Recommendation Report for Planning Permission for Works or Extension to a Dwelling

REF NO: EP/33/21/HH

LOCATION: 6 Upper Drive
East Preston
BN16 1QN

PROPOSAL: Single storey front extension.

Project:	
Proposed extension; Fairwinds, 6 Upper Drive, East Preston BN16 1QN	
Drawing:	
Ground floor	
For:	
Mr. & Mrs. D. Murphy	
Drawn:	Date:
PKS	March 2021
Scales:	No:
1:50 1:500	2753/01/03
To scale when printed on A3

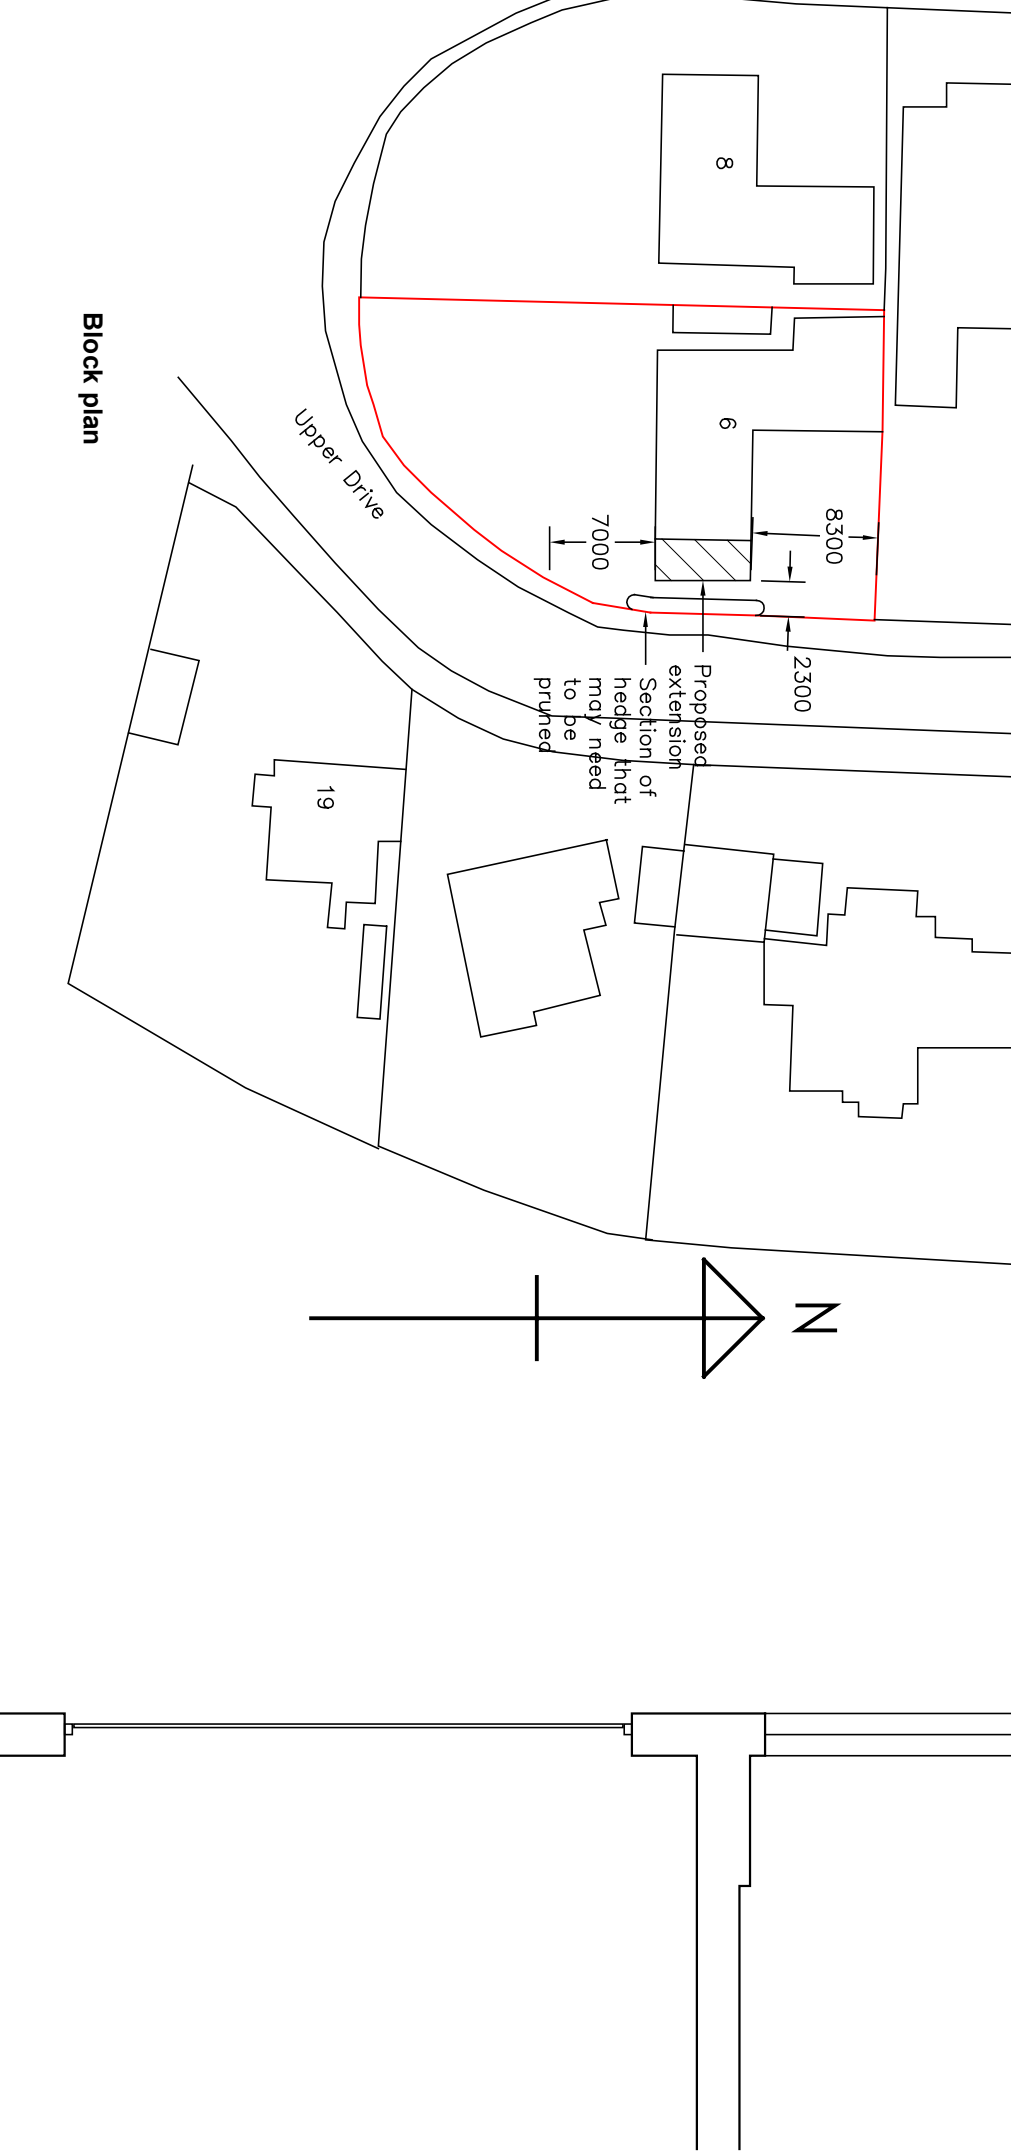
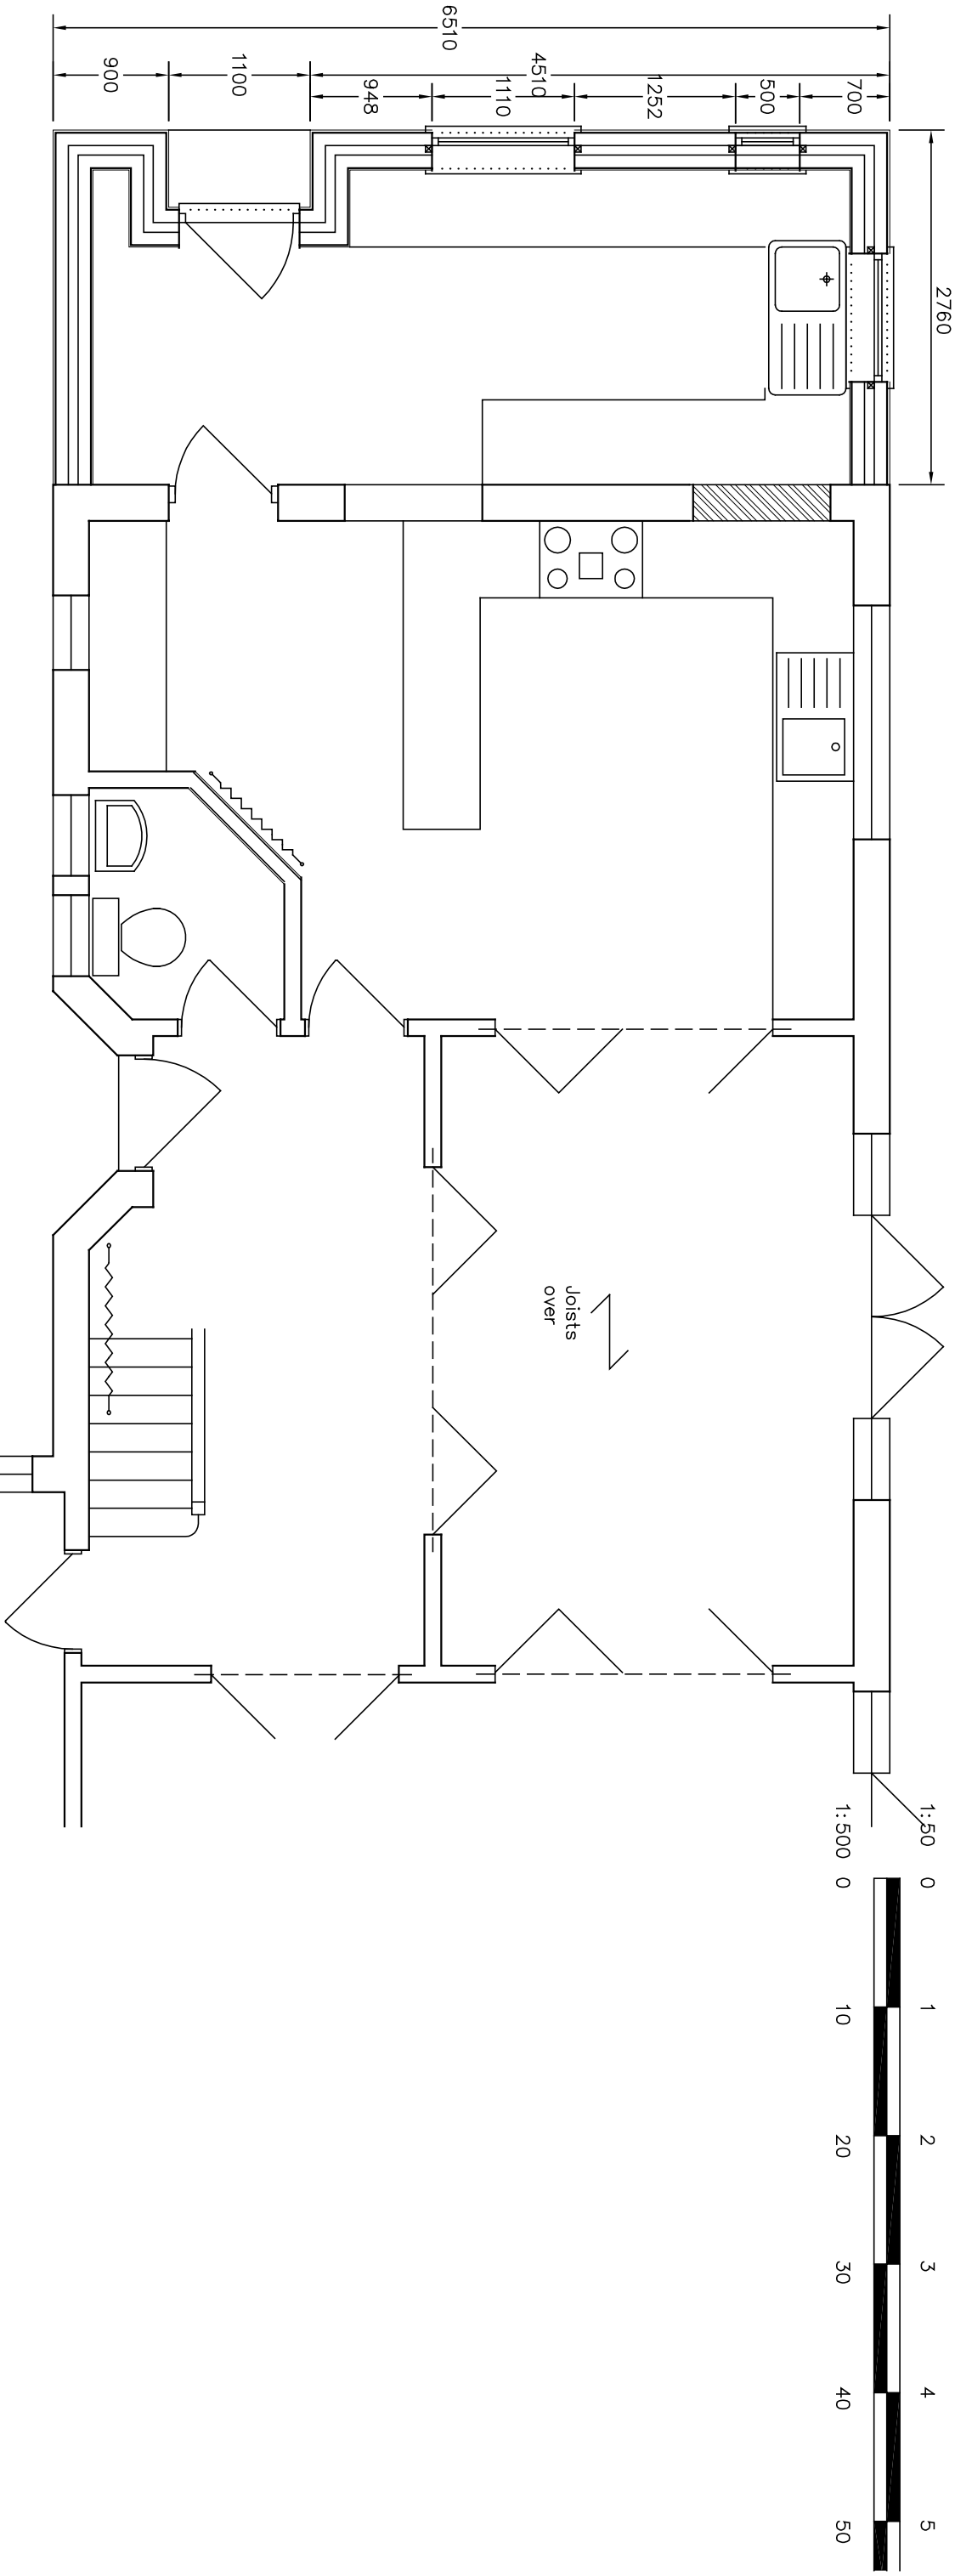
The property is on a corner plot of Upper Drive and Manor Road. The extension is to the front protruding from the eastern (principle) elevation; the extension will contain a separate utility area. The extension is of an appropriate size and scale for its intended use.

Drawing:
Plans and elevations as proposed

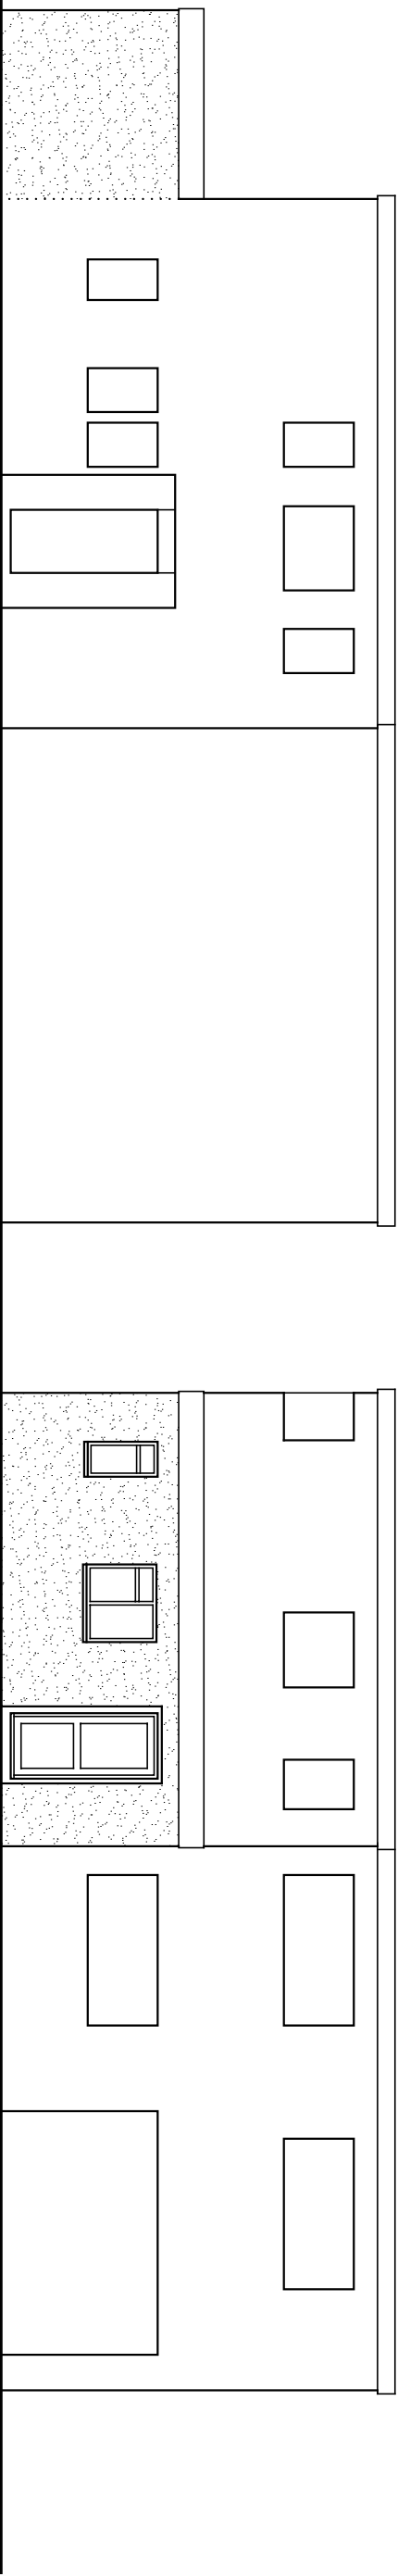
The dwelling is a flat roof 2 storey dwelling, the eaves line of the extension, being single storey, will be significantly lower than existing. The extension is of materials like those found on the dwelling and relate well to the existing style found on site.

The extension will be highly visible from multiple points on the street, especially with the thinning of an existing mature boundary hedge on site. As a single storey protrusion, adjoining the 2-storey host dwelling it will be subservient to the dwelling and not detrimental to the streetscape. The space around the building will be similar to that currently found in the surrounding area.

The fenestration proposed on the south elevation of the extension will only achieve views into the private amenity space of the host dwelling there are no issues foreseen relating to overlooking.
